CITY OF PORTLAND, MAINE
PLANNING BOARD

November 3, 2003

RE: 280 Fore Street

The approval is for a six-story office and parking structure located at the corner of Fore Street and Franklin Arterial.

A1 FORE STREET ELEVATION  
 1/8"=1'-0" AE100, AE101, AE102, AE103, AE104, AE105

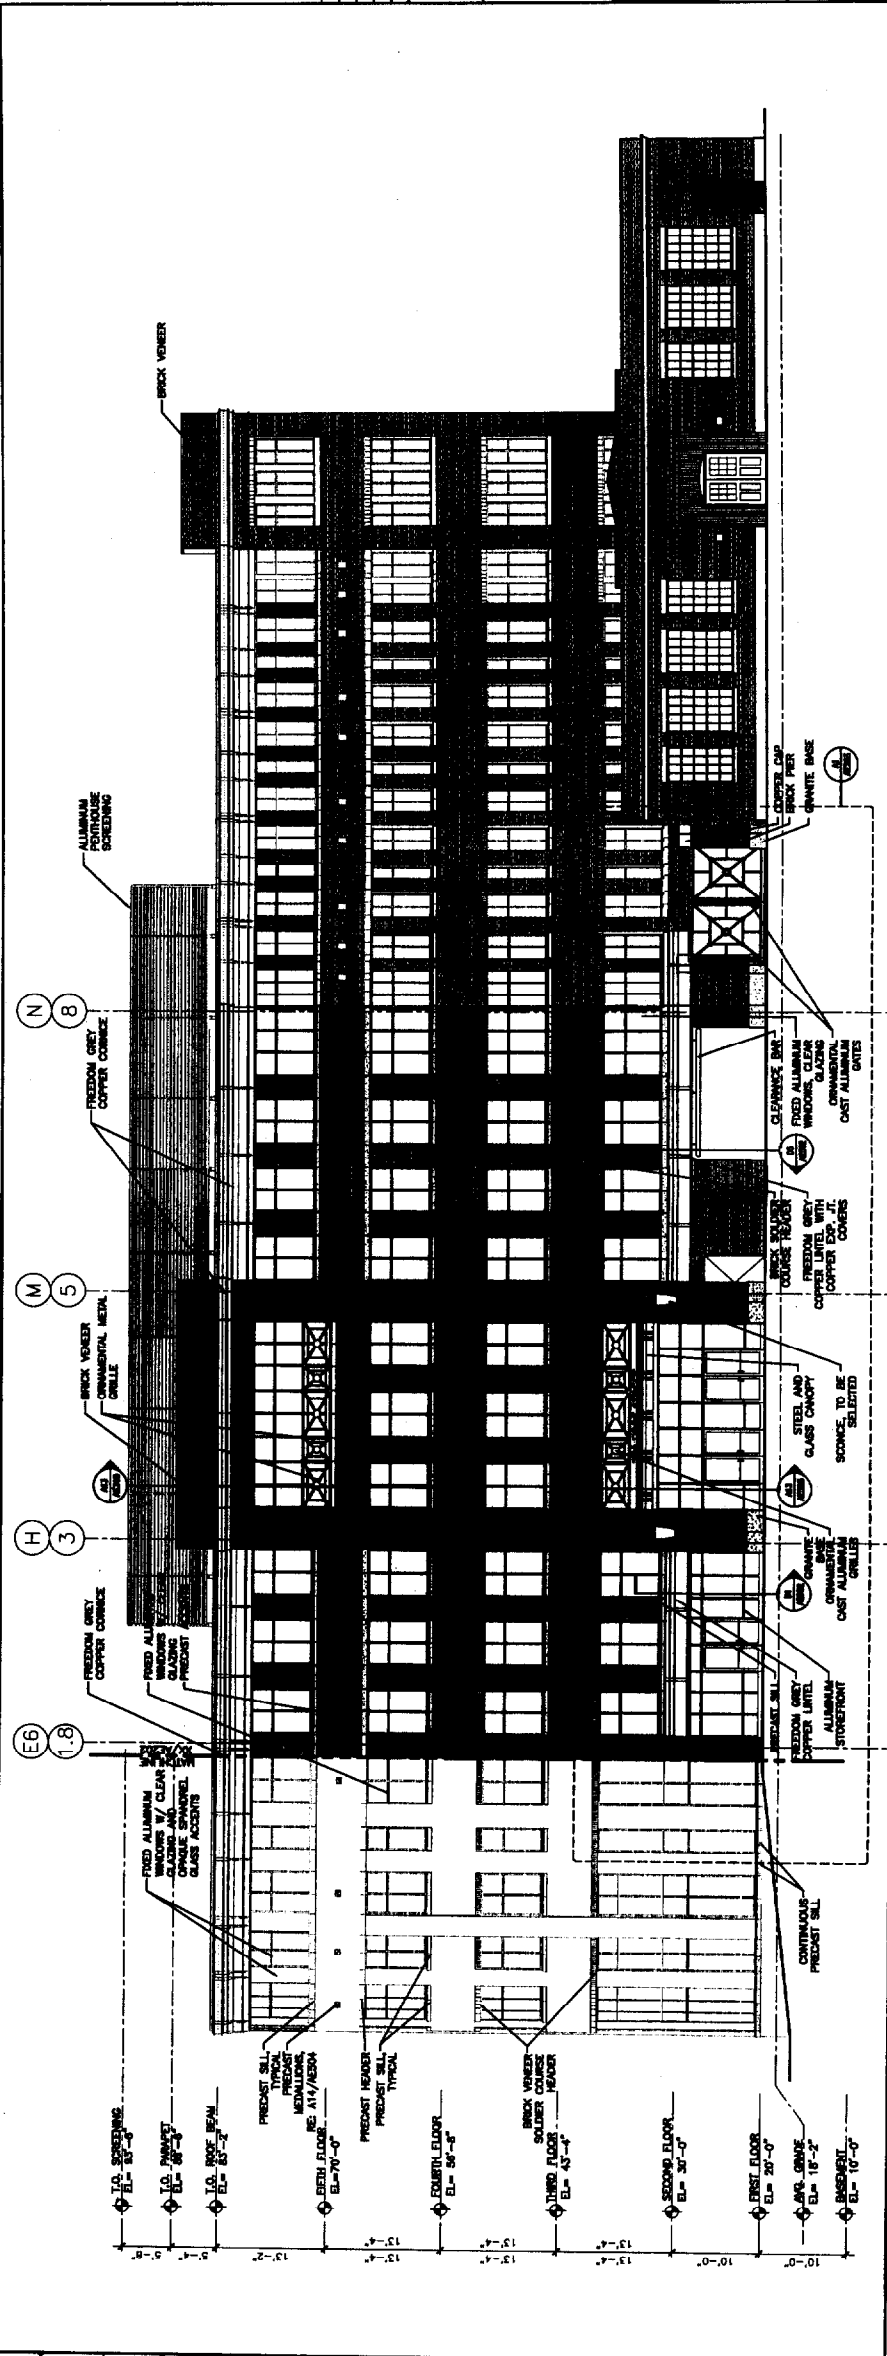
1. *That the projecting entrance bay on the on the Fore Street elevation continue at its full depth to the roofline, rather than step back at the fifth floor.*
2. *That an alternative design for the proposed wall projections above the cornice be presented for final review and approval by the Historic Preservation Committee.*
